COUNTY COUNCIL'S RESPONSE TO CONSULTATION ON THE FOLLOWING DEVELOPMENT PROPOSAL

Application No: 18/00193/REM-3

Proposal: Reserved matters application to 14/02156/OUT - for appearance, landscaping and layout (including the layout of the internal access roads, footpaths and cycleways) for 37 dwellings.

Location: Land South Of Cotefield Business Park, Oxford Road, Bodicote.

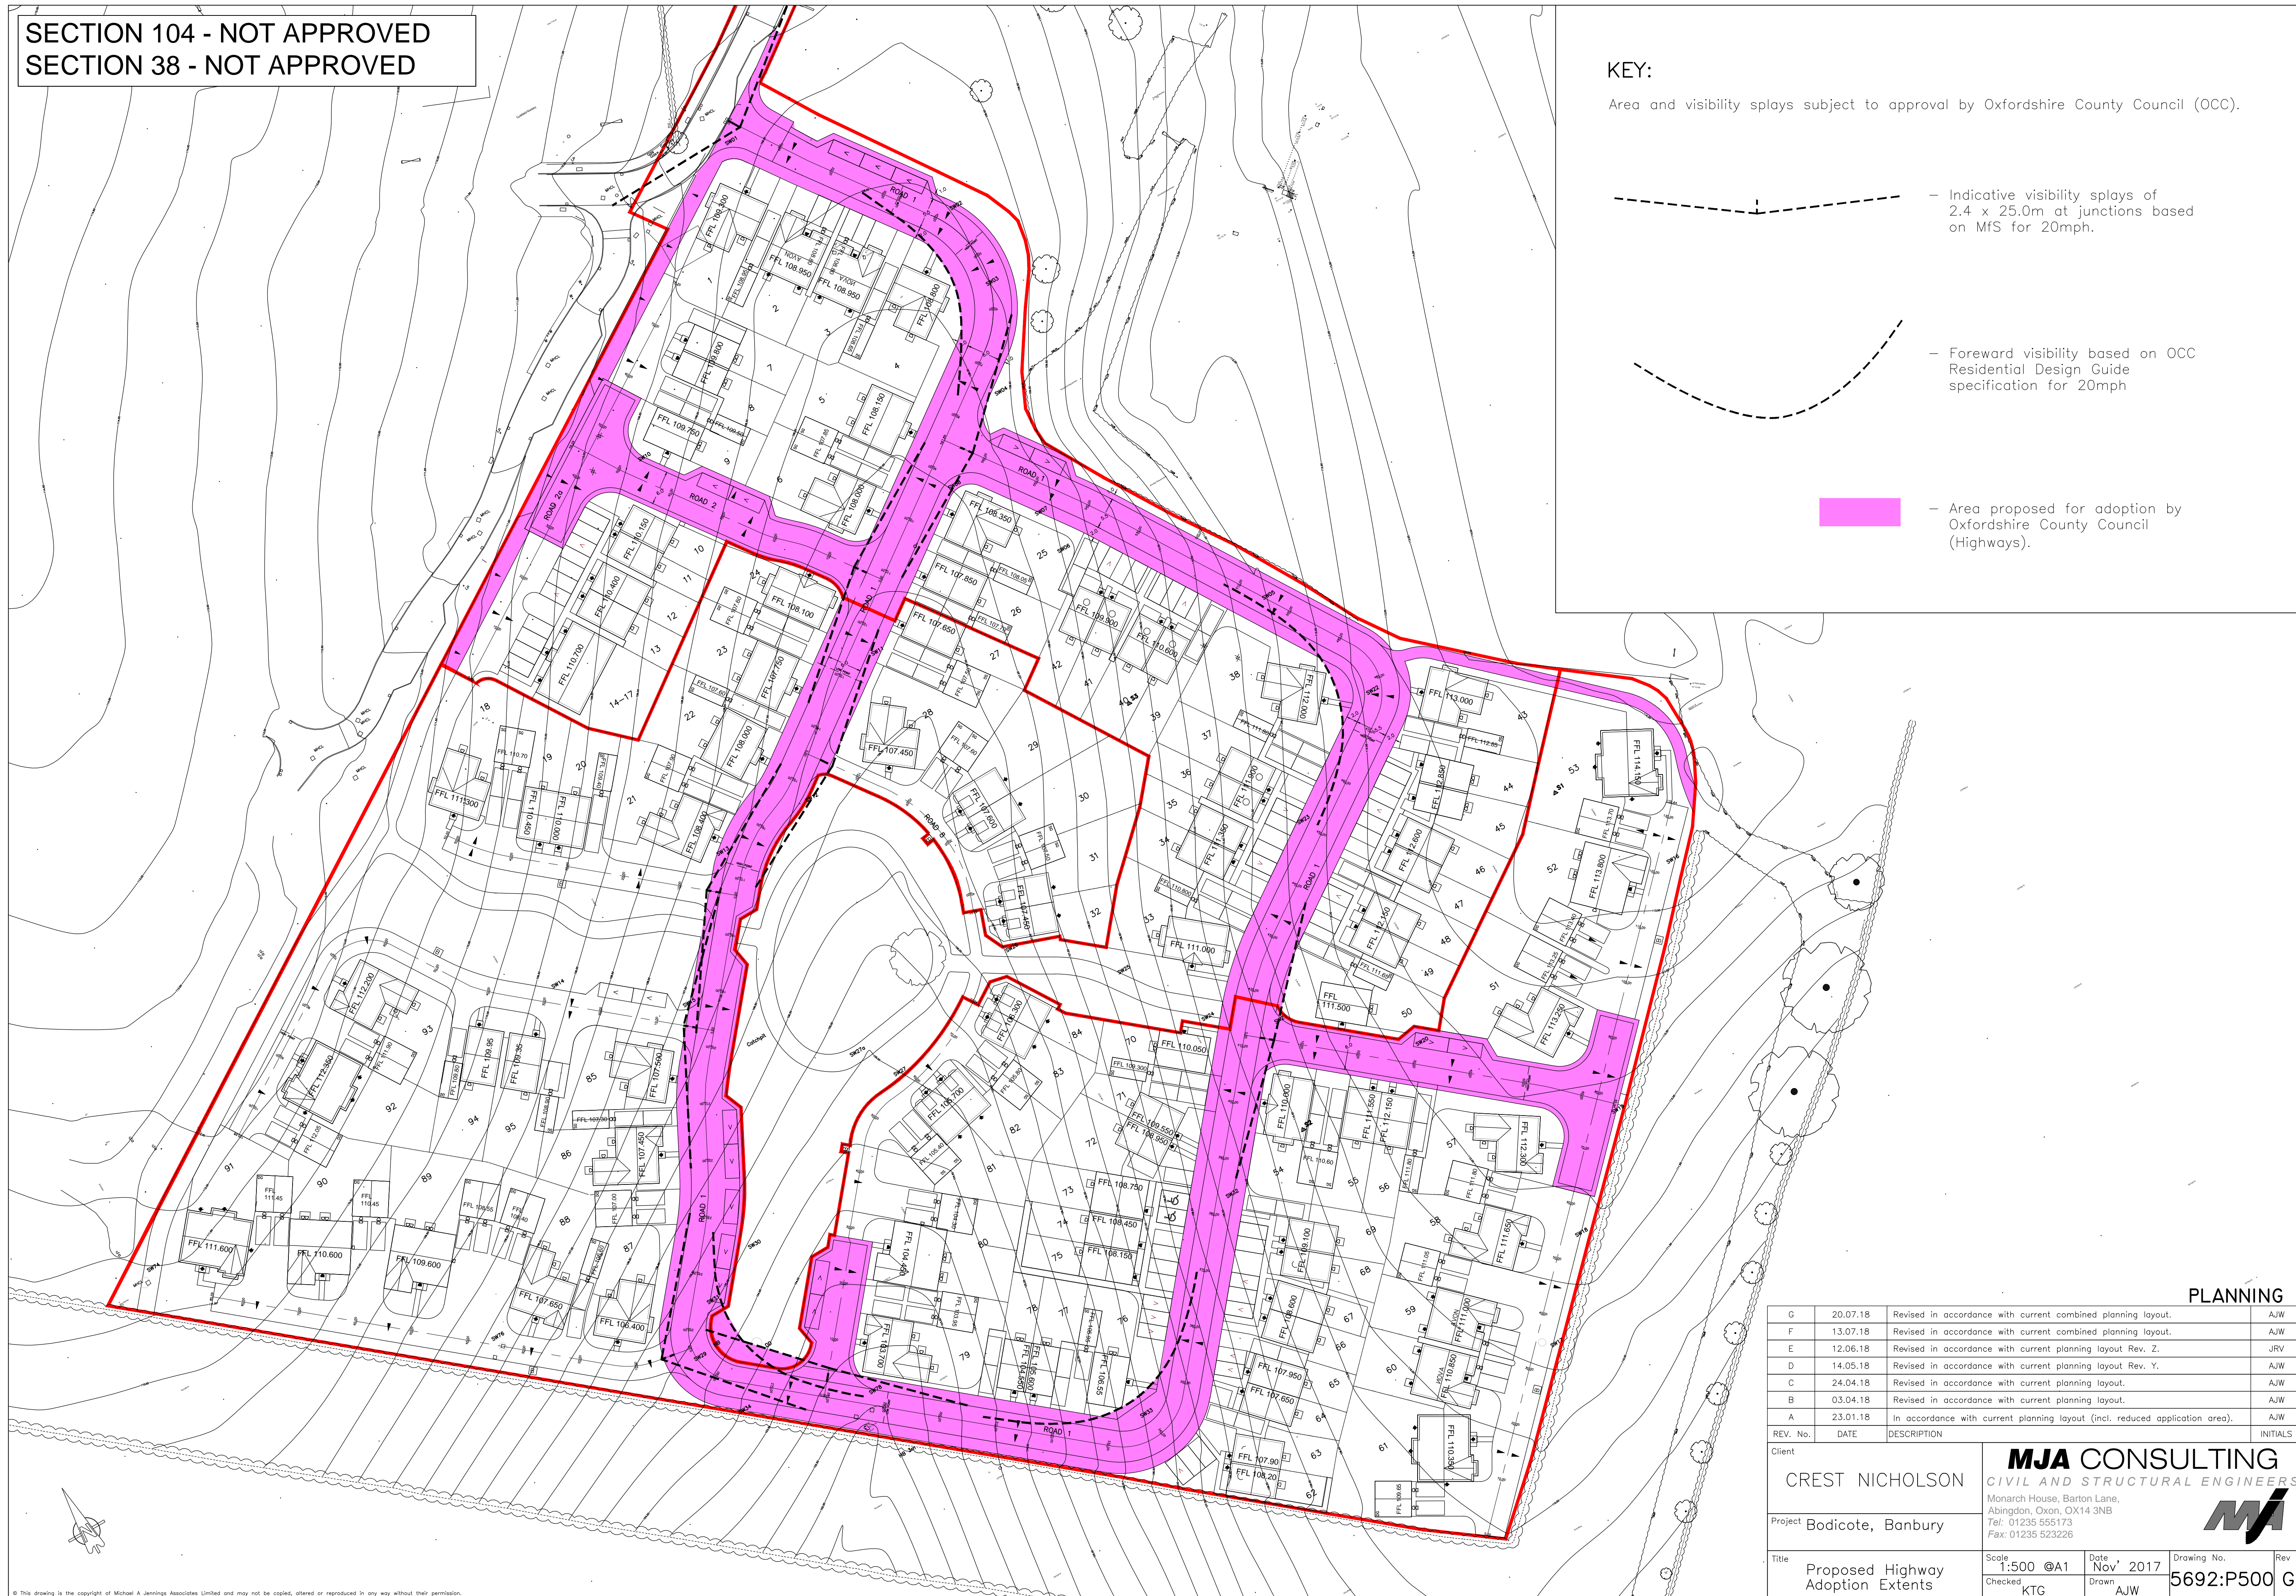
The applicant has submitted Drawing No. P16-1364_01 Rev. AD, an amended development layout, and Drawing No. 5692: P500 Rev. G, a highway adoption plan. The red line boundaries for the development are different on these two drawings. However, I will flag up issues that I think are relevant to both developments. Firstly, forward visibility splays that are in accordance with the design speed of the development and Manual for Streets need to be included on the bend immediately north of the access to plots 1-37 on Drawing No. P16-1364_01 Rev. AD.

The forward visibility splay for drivers travelling in a south-westerly direction immediately south of Plot 87 on Drawing No. 5692: P500 Rev. G points through a visitor parking space. This is not enabling safe access to all parts of the development in accordance with Manual for Streets, so the Local Highway Authority would not be able to adopt this stretch of the access road. The visitor space could be moved further eastwards by removing the gaps between visitor spaces within this batch which could be butted up.

The Local Highway Authority would not adopt the access road that serves plots 79 and 80 on Drawing No. 5692: P500 Rev. G as it only serves two dwellings.
